June 16, 2021  
Harnett County Development Services  
Attn: Donna M. Johnson, Central Permitting Division  
108 E. Front Street  
Lillington NC 27546  
(910) 814-6431

**Project: Sheetz (Cameron)**  
**Location: Sawyer Road & Hwy. 24, Cameron NC 28326**  
**UST RESPONSE LETTER**

TIE DOWNS FOR UNDERGROUND STORAGE TANKS (UST)

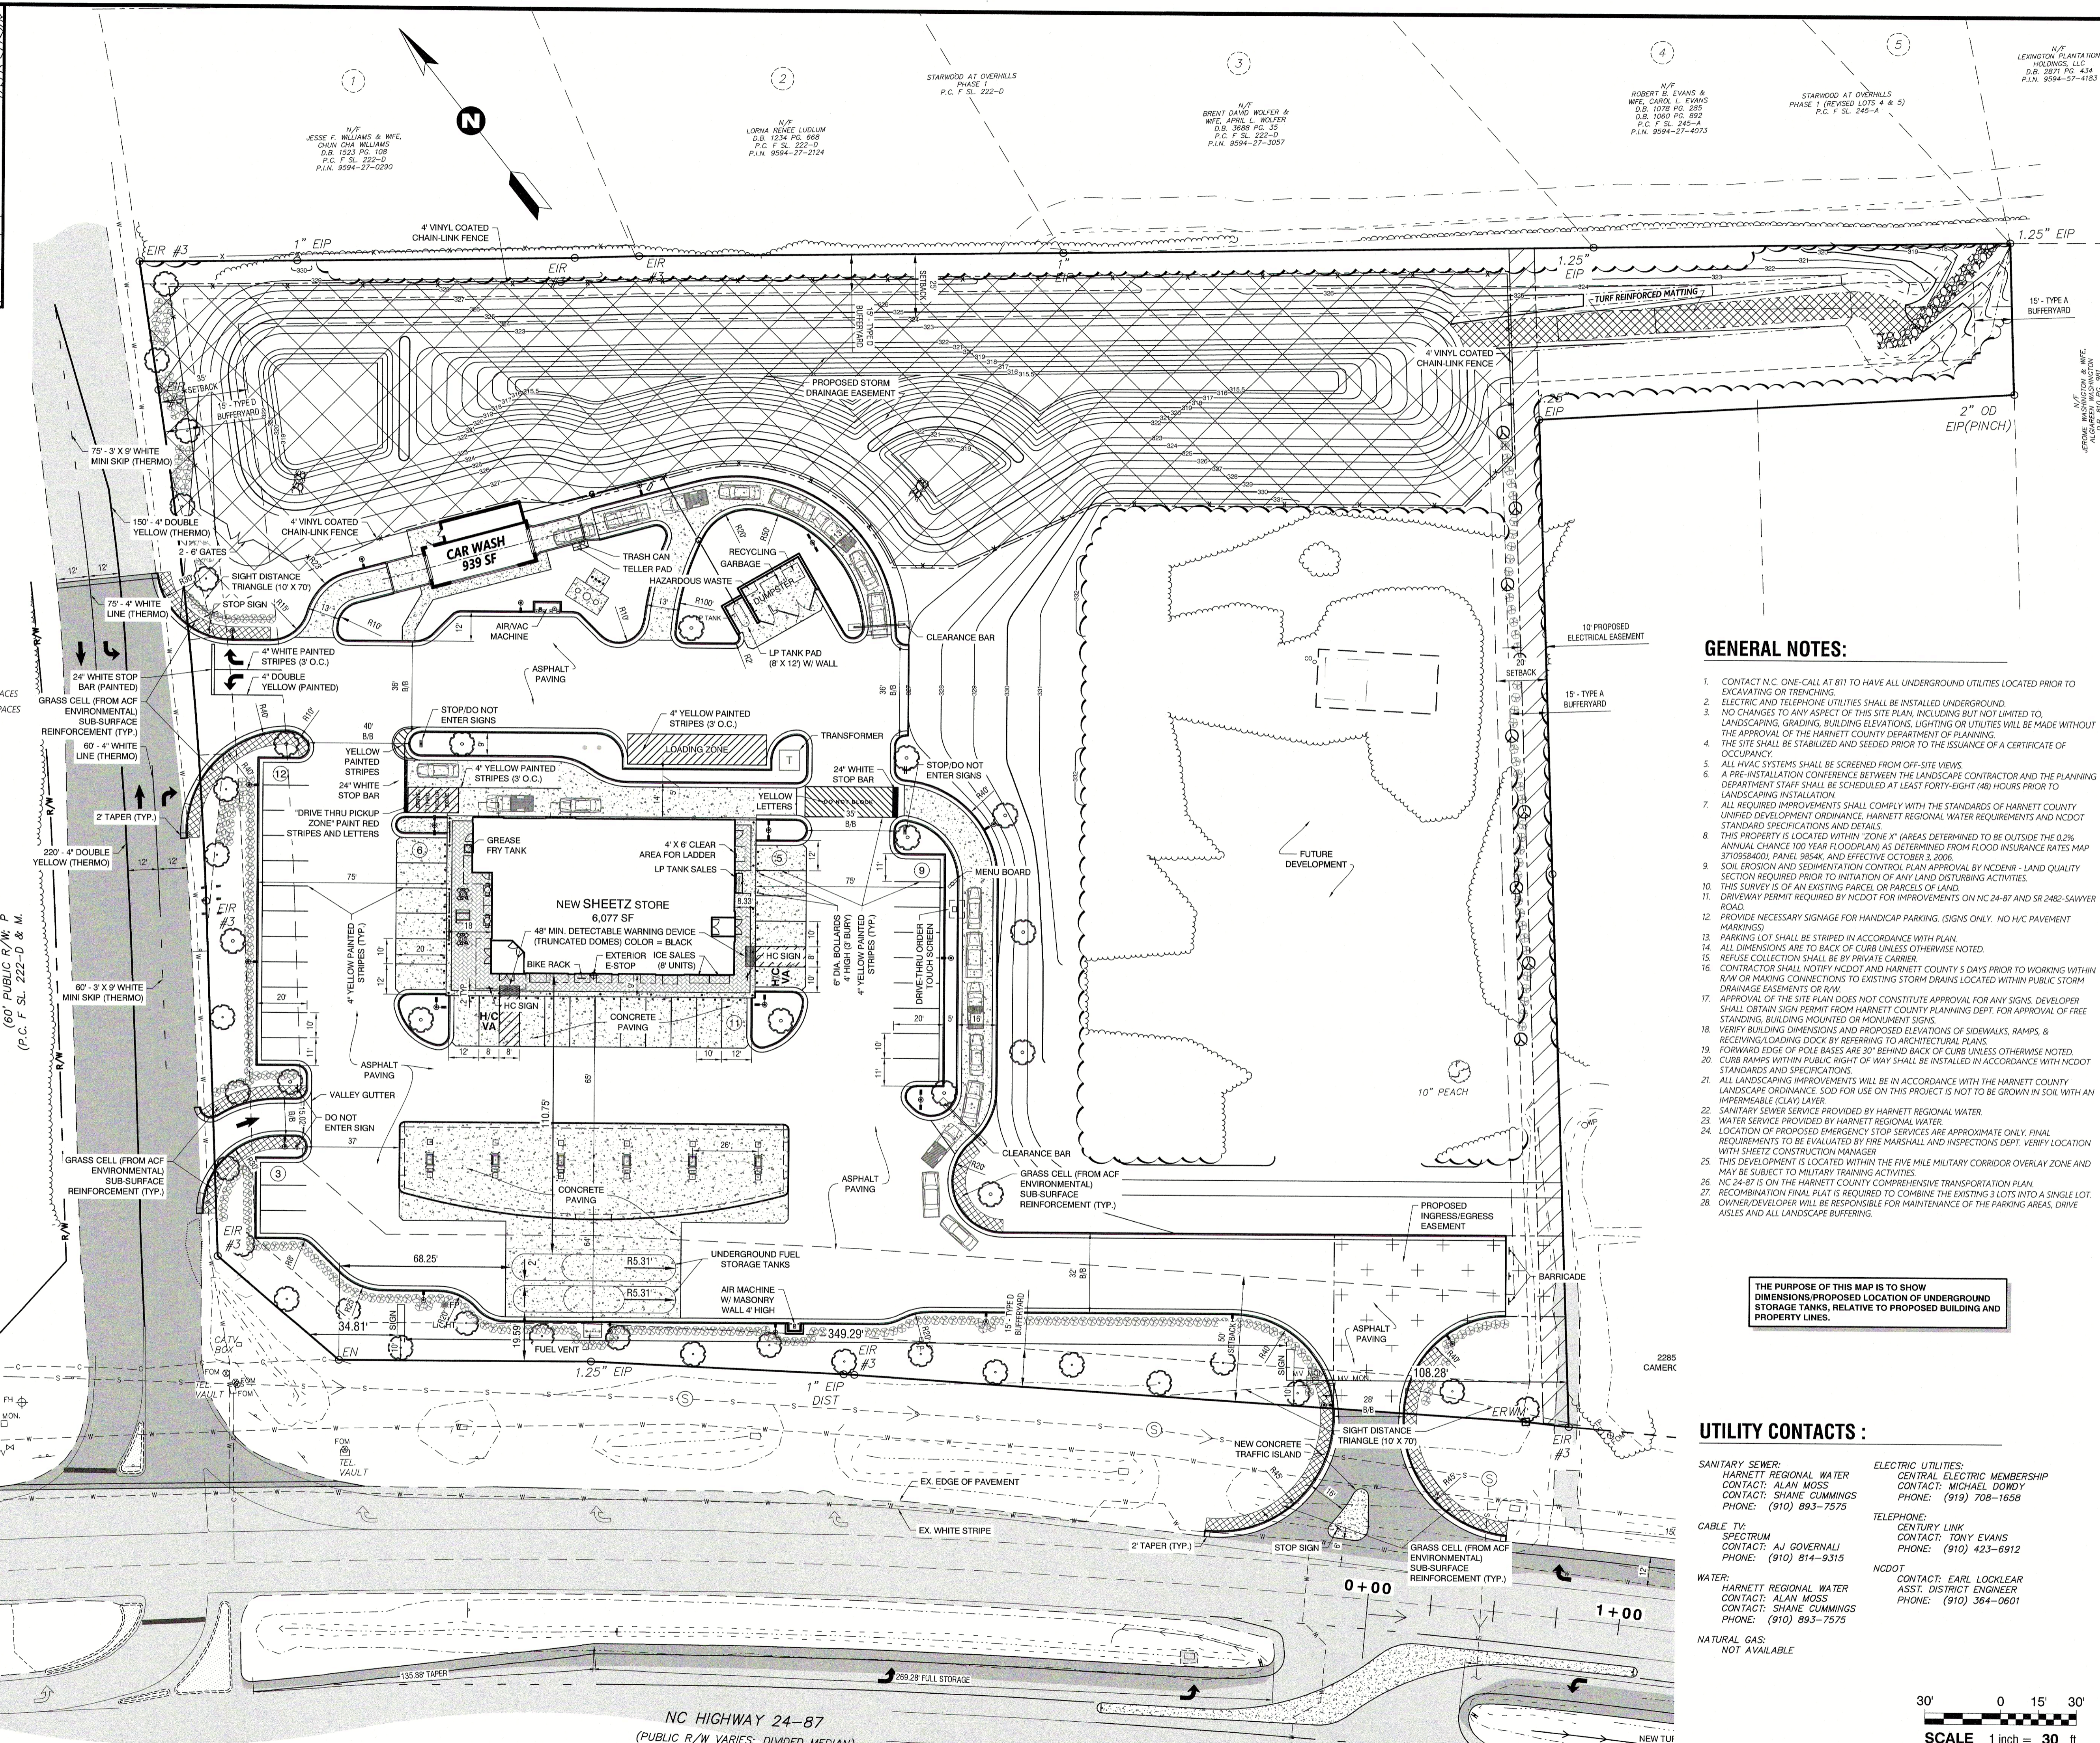
1. Sets of plans shall be submitted for review. Plans shall indicate the following:
  - a. Site plan indicating the exact placement of tank(s) with setbacks from buildings and lot lines.

**RESPONSE: See attached Placement of UST Plans**
  - b. Indicate the type of product that will be stored in the tank(s).  
**RESPONSE: Covered on FT2.1 Detail B, as well as on multiple other pages.**
